Sent: 25 May 2012 17:27
To: Planning
Subject: Planning Application No: N6/2012/0854/MA - Hertfordshire Constabulary, Stanborough Road, Welwyn Garden City

Planning Application No: N6/2012/0854/MA - Hertfordshire Constabulary, Stanborough Road, Welwyn Garden City

drawing
EXISTING SITE PLAN INDICATING FIELD AS EXISTING

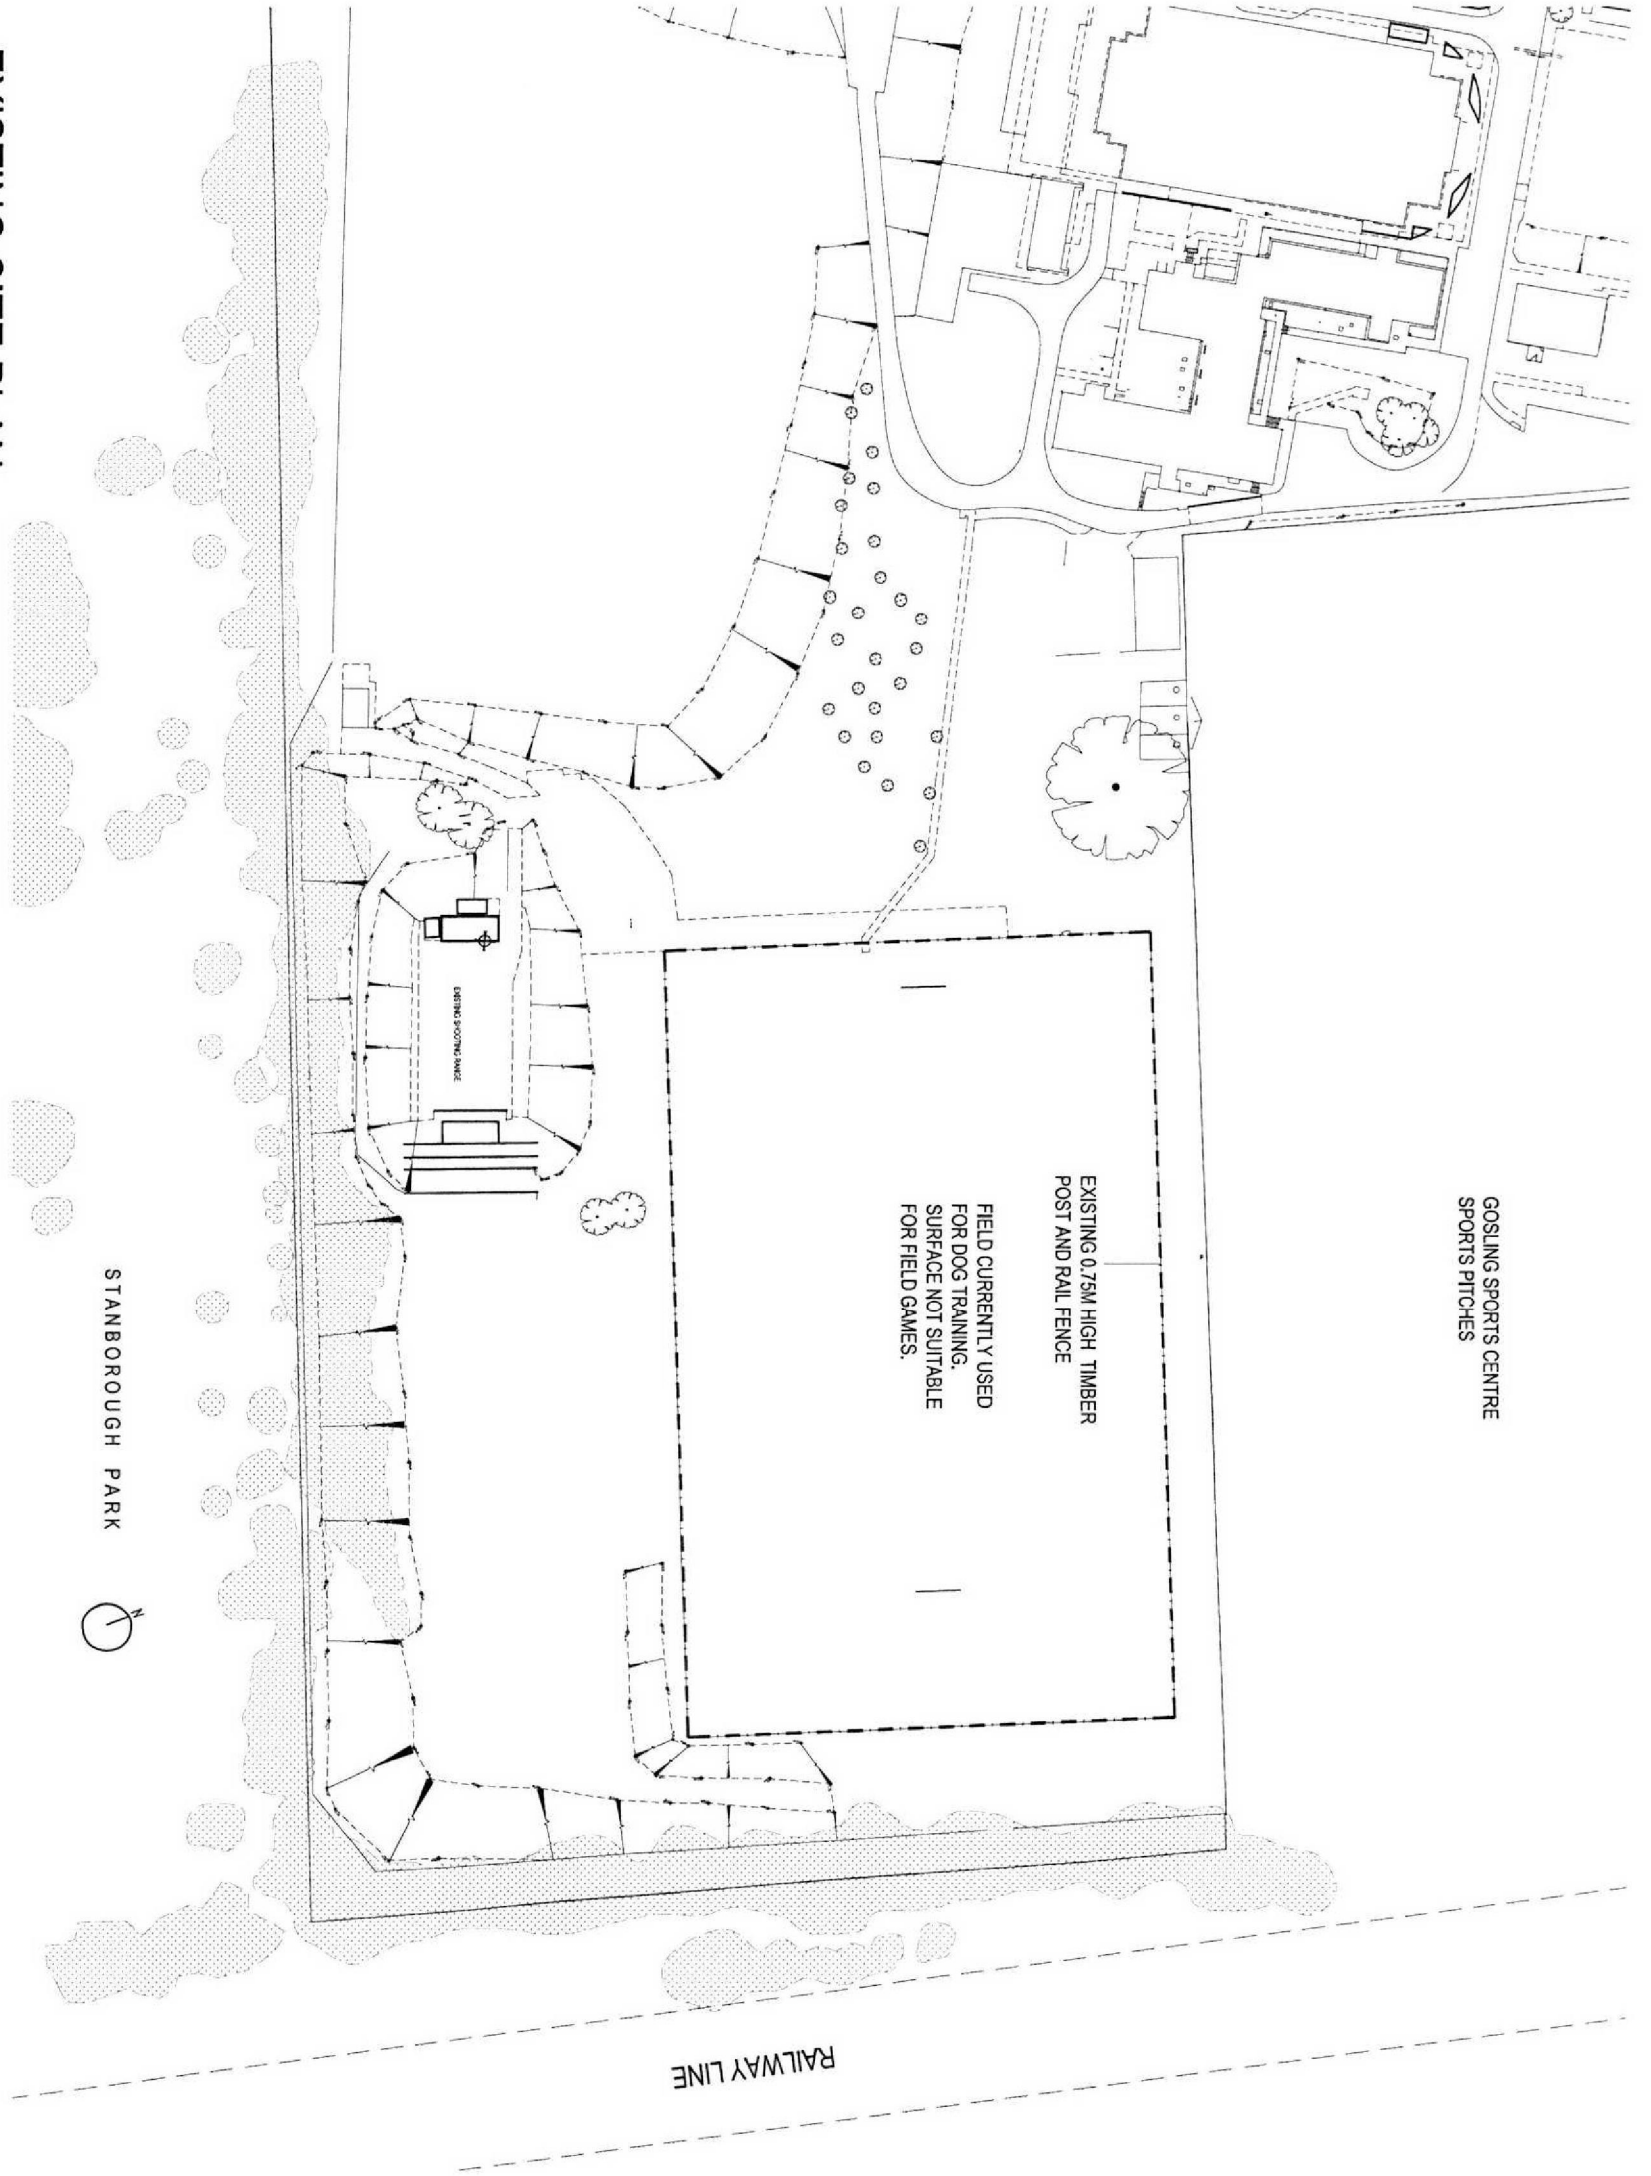
1. Existing Playing Pitch Layouts: Site plans (to scale) showing the existing playing pitch layout (both winter and summer if applicable) of the playing field. This information is required to make an informed assessment of the impact of the proposals on existing playing pitch provision. The plans submitted do not show any existing football, rugby, cricket etc pitches.

drawing
PROPOSED SITE PLAN INDICATING FIELD AS PROPOSED

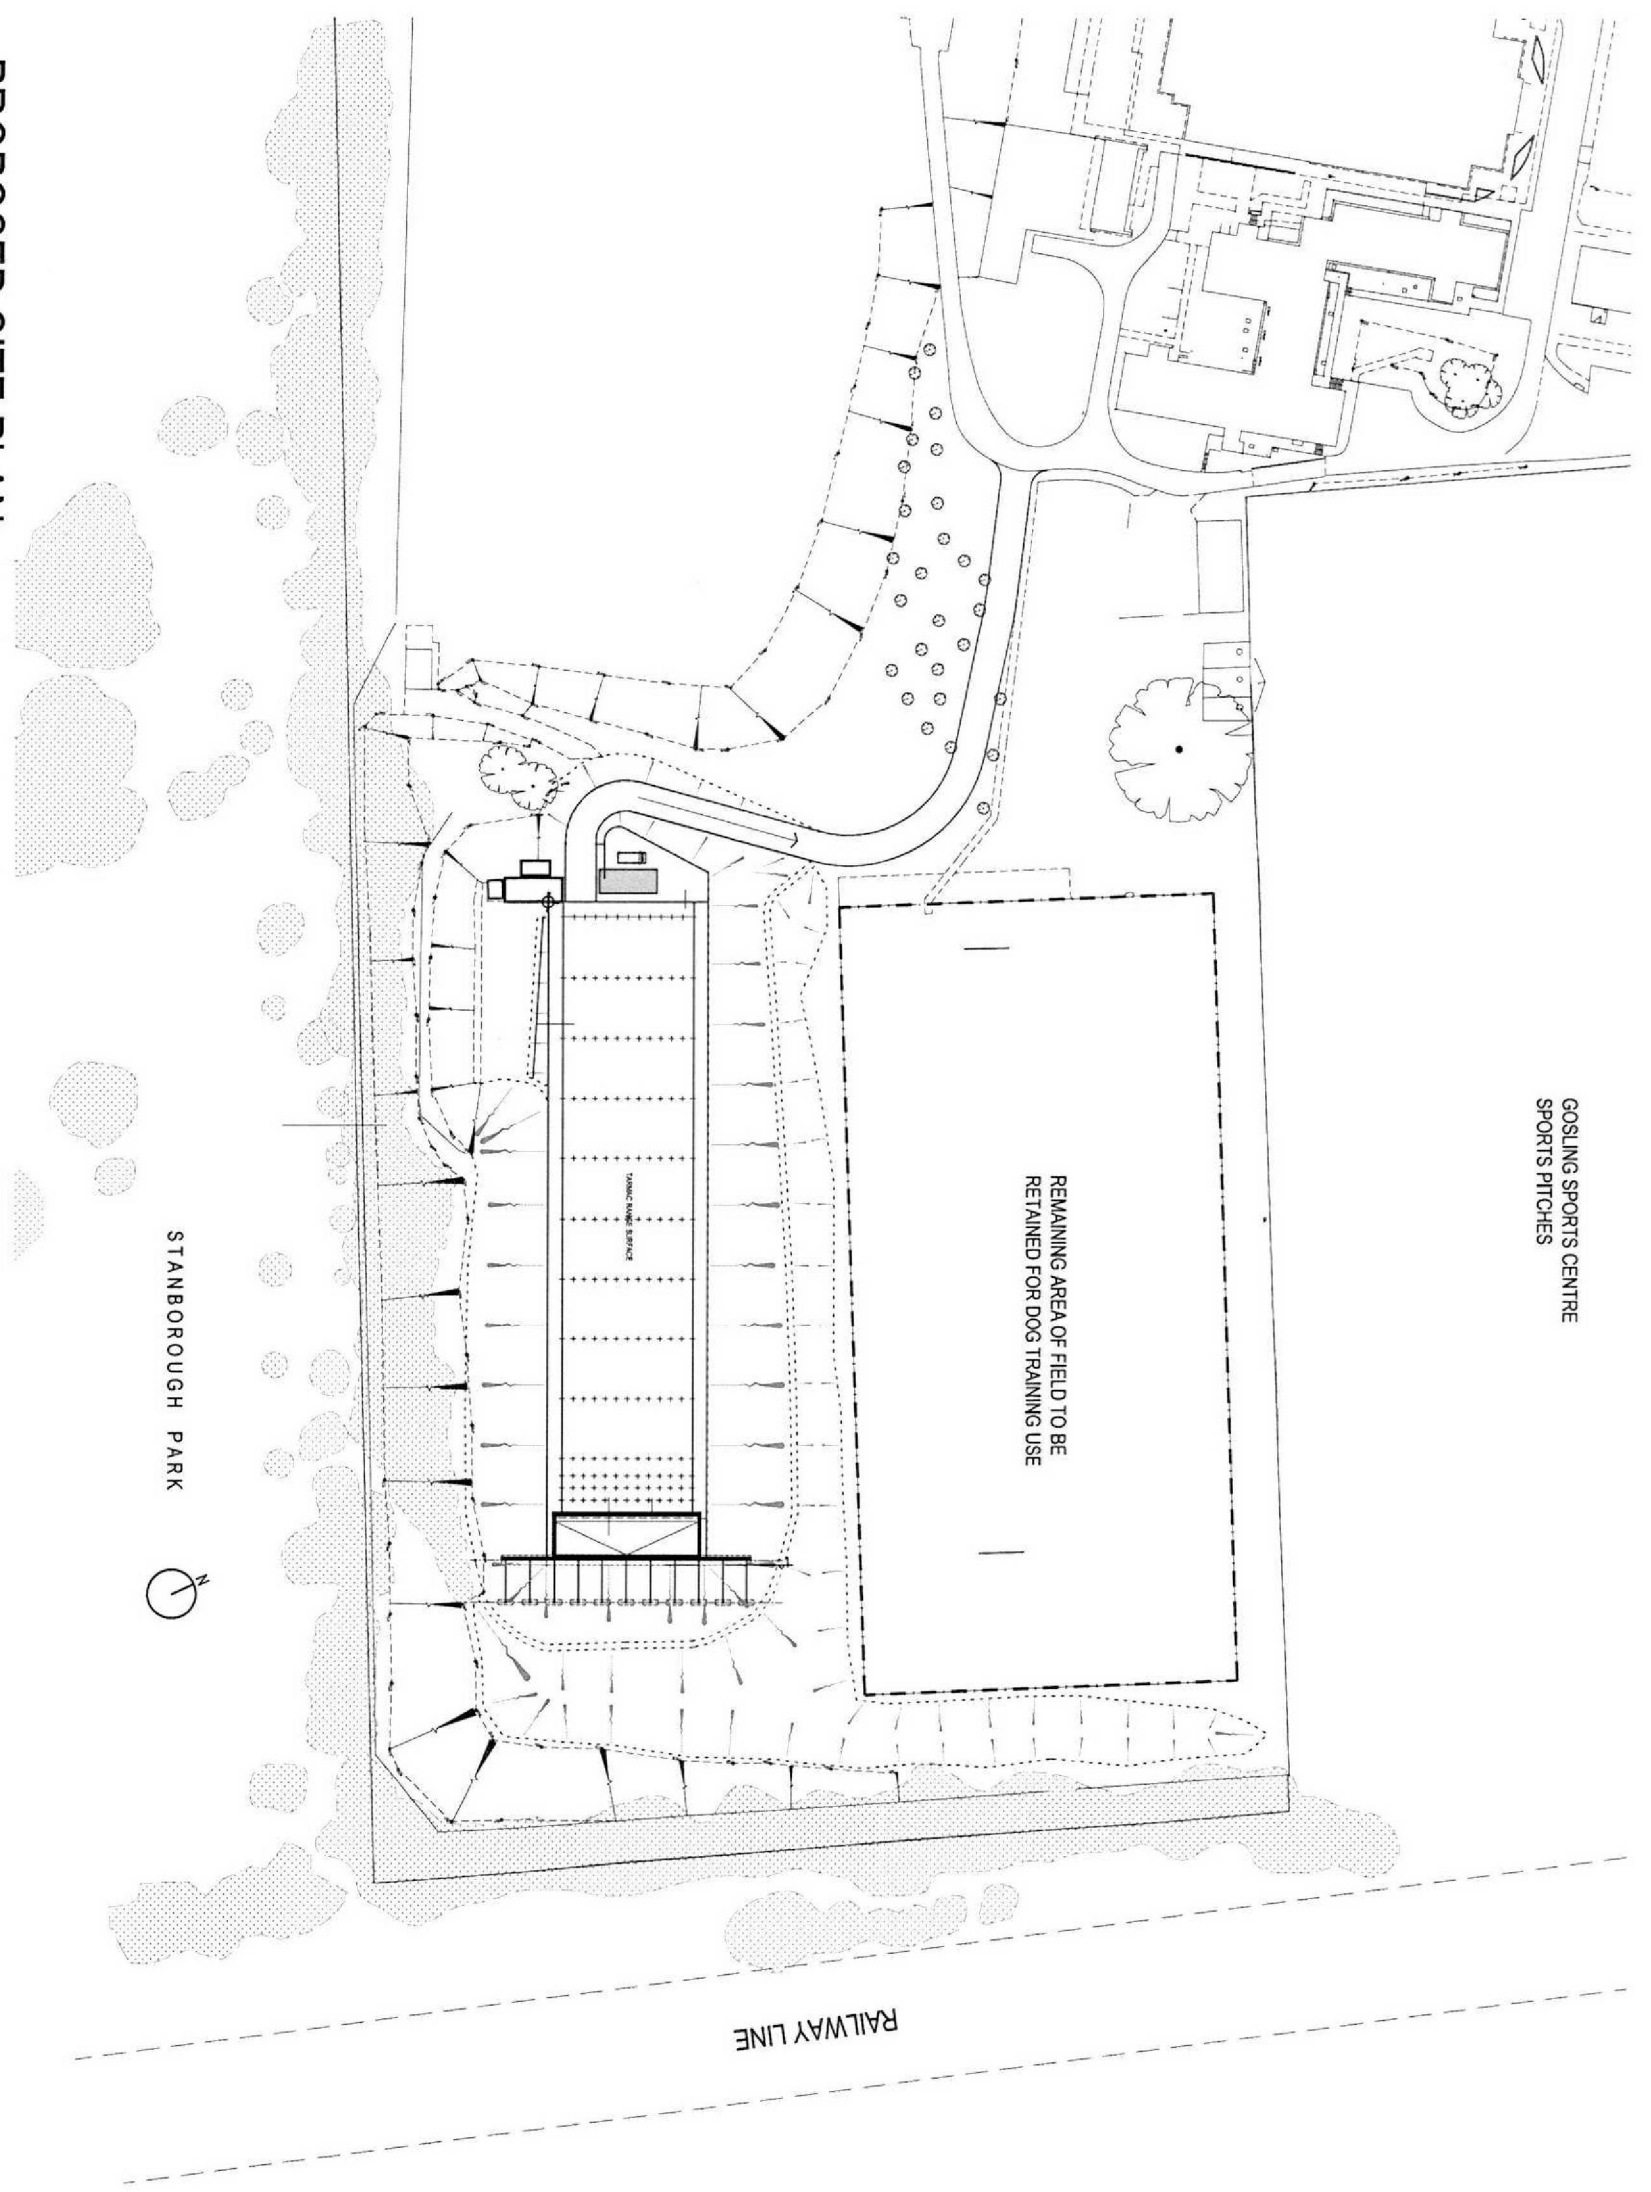
2. Proposed Playing Pitch Layouts: Site plans (to scale) showing the proposed playing pitch layout (both winter and summer if applicable) of the playing field after the development has been implemented. This information is required to make an informed assessment of the impact of the proposals on playing pitch provision. The plans submitted do not show any proposed football, rugby, cricket etc pitches to allow comparison to be made to the existing pitch layouts.
